This letter is intended to serve as a comment response letter for the Amara Annexation, Master Plan, and Zoning Second Review of the above requested application dated January 25, 2022, and Revised March 28, 2022. This letter is to accommodate the requested resubmitted plans and documents associated with the application.

RE: Amara (Annexation, Mater Plan and Zoning) - Second Review Comments
File: CPC A 21-00197 - CPC A 21-00207, CPC MP 21-00208, CPC ZC 21-00209

CITY FILE NO. CPC A 21-00207
610 N. Comstock Avenue, Suite 200
Orem, UT 84057
(801) 225-0790
(801) 225-0799 (FAX)

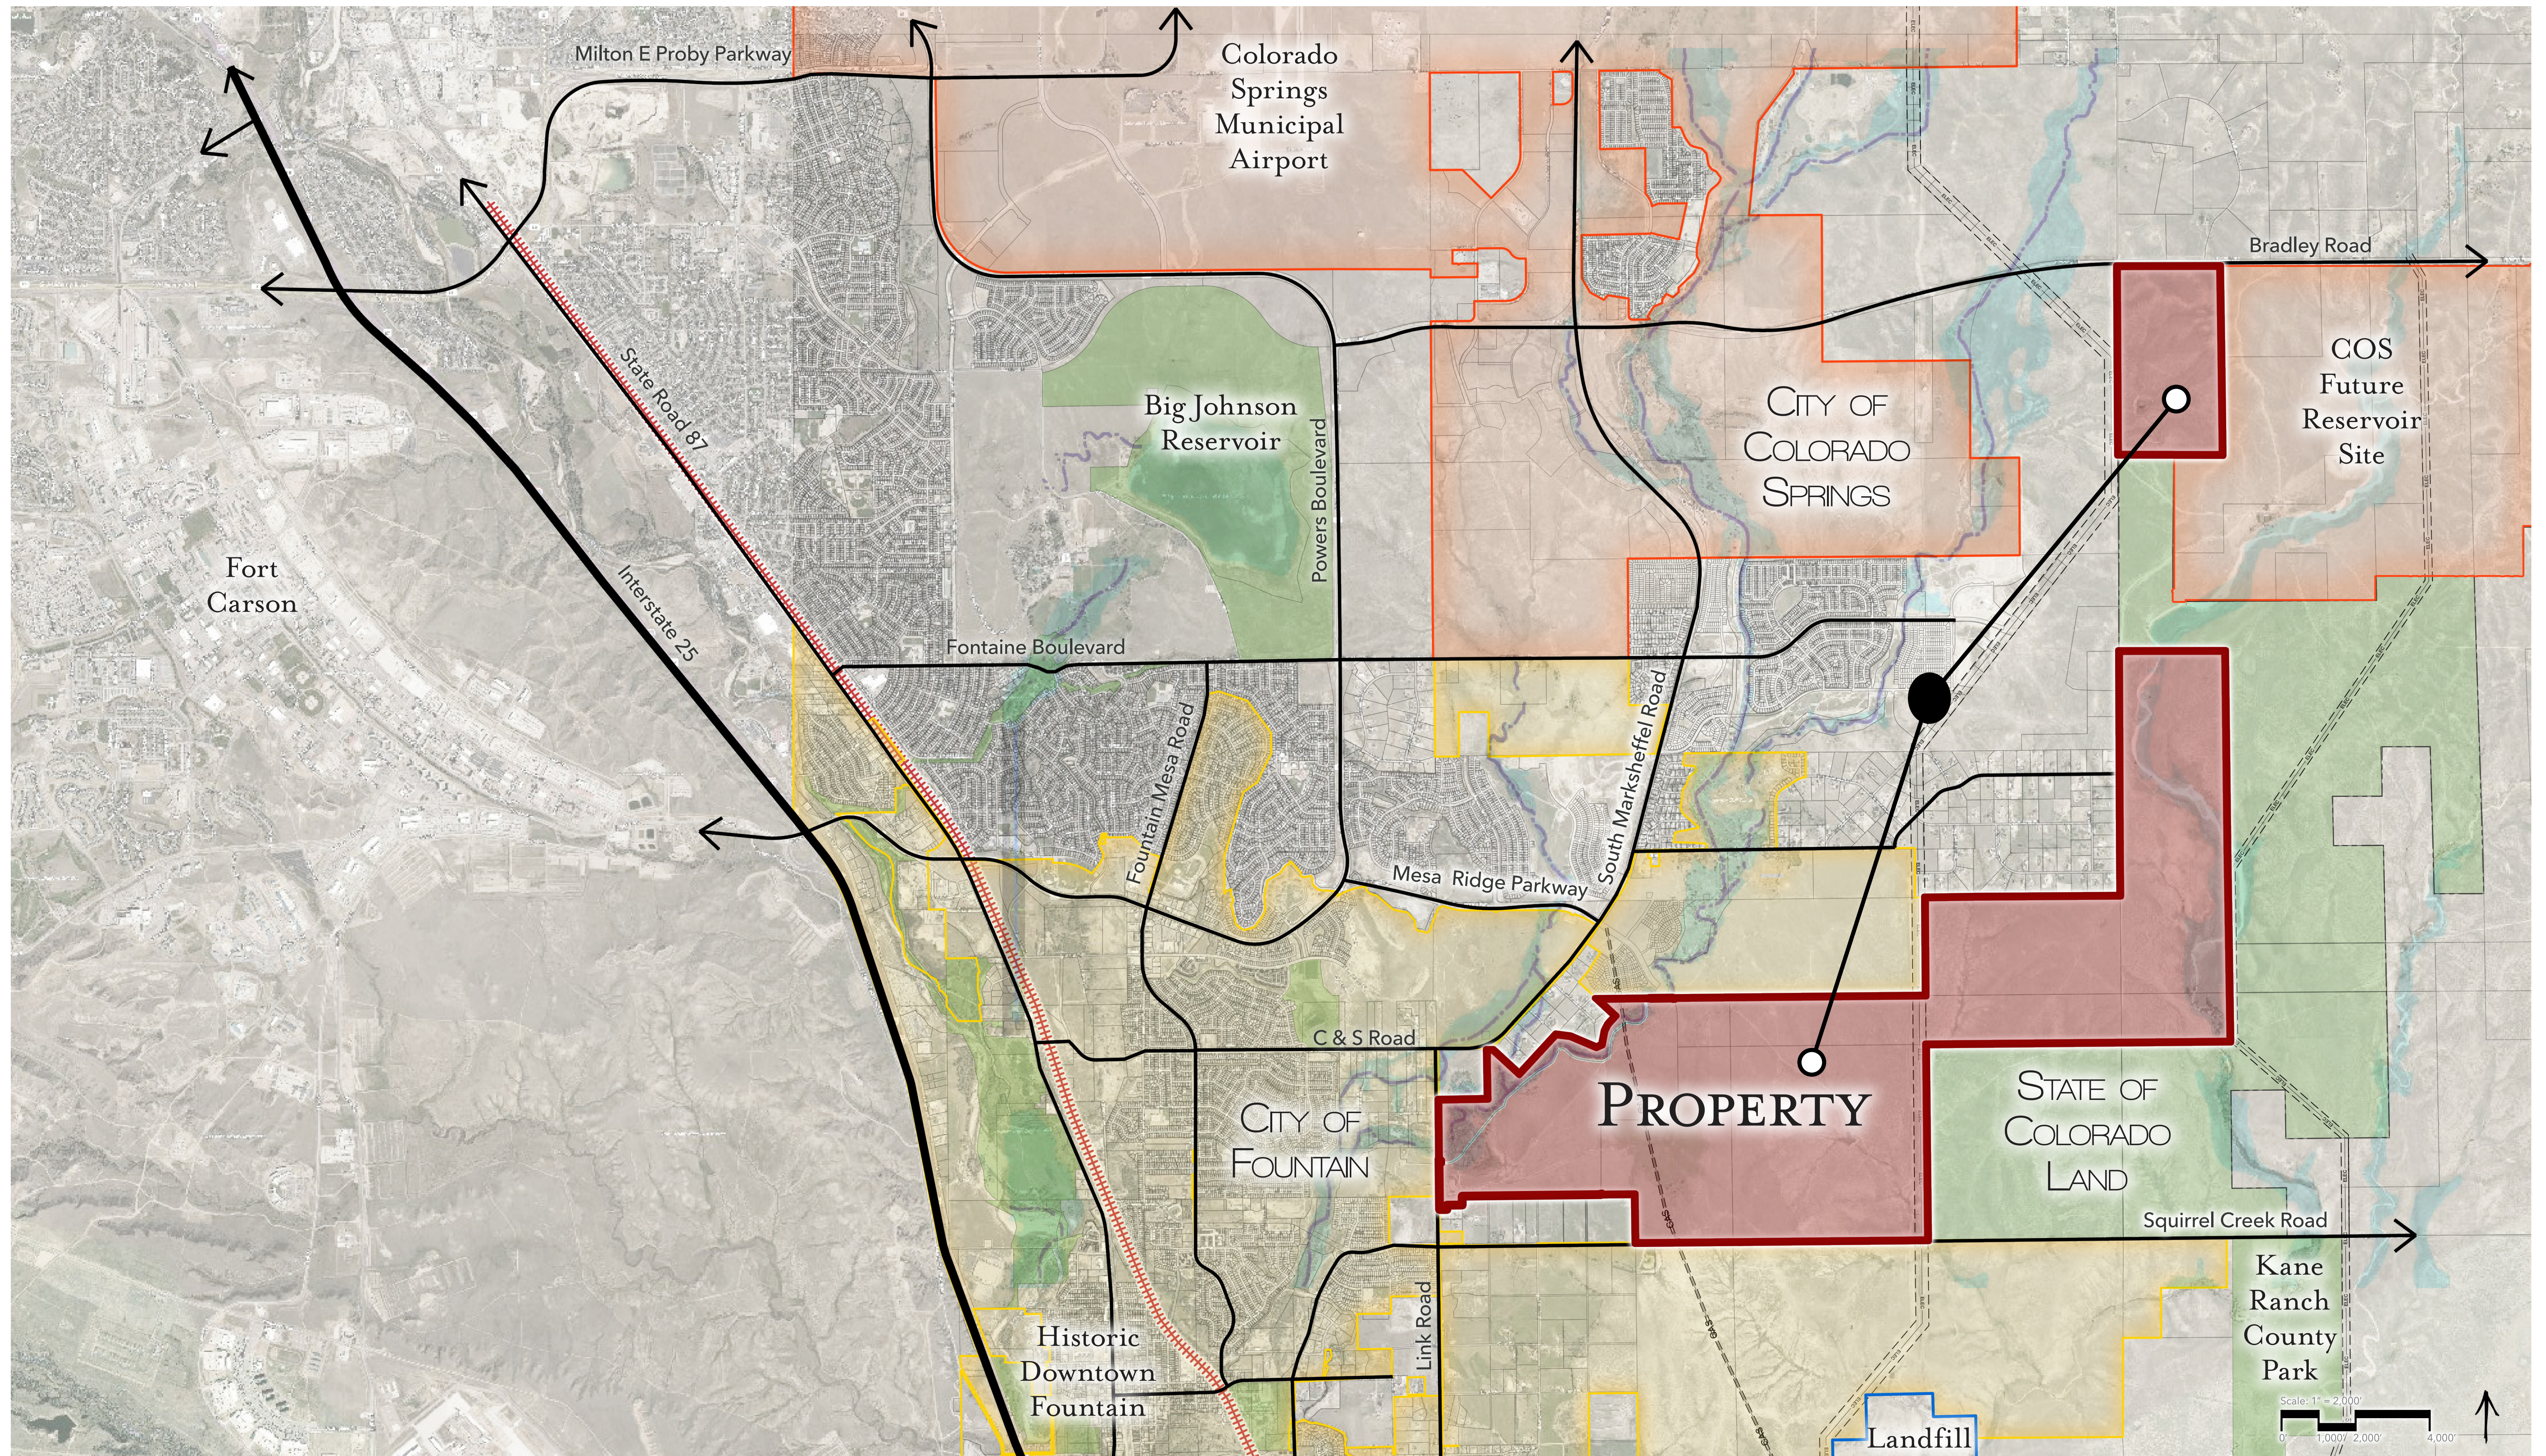
1. Please add the missing "be it known by these presents". - **Revised**
2. Please complete the City File No. CPC A 21-00207. - **Revised**

3. Please add the distance to the third course within the legal description (S 01-07-56 E 2629.96').
- **Revised**
4. When adding the area with a calculator the total perimeter is 30800.63', please verify. -
Revised

5. Please add some additional section labels for section 26 and 27. - **Revised as possible**
6. Please label the lot numbers in Fountain Valley Land & Irrigation Co. Subdivision No. 1. -
Revised

7. Please depict and label the Fountain Mutual Irrigation ditch as it cross the property and should tie into the canal as depicted on the adjacent plat to the south. - **Revised**

8. Please add the record information for Squirrel Creek Road. - **Revised**
9. Please check the line as depicted for the easterly line of the southeast quarter of section 33, as the monuments location lies easterly of the line as depicted. - **Revised**

Response: See above responses for each number.
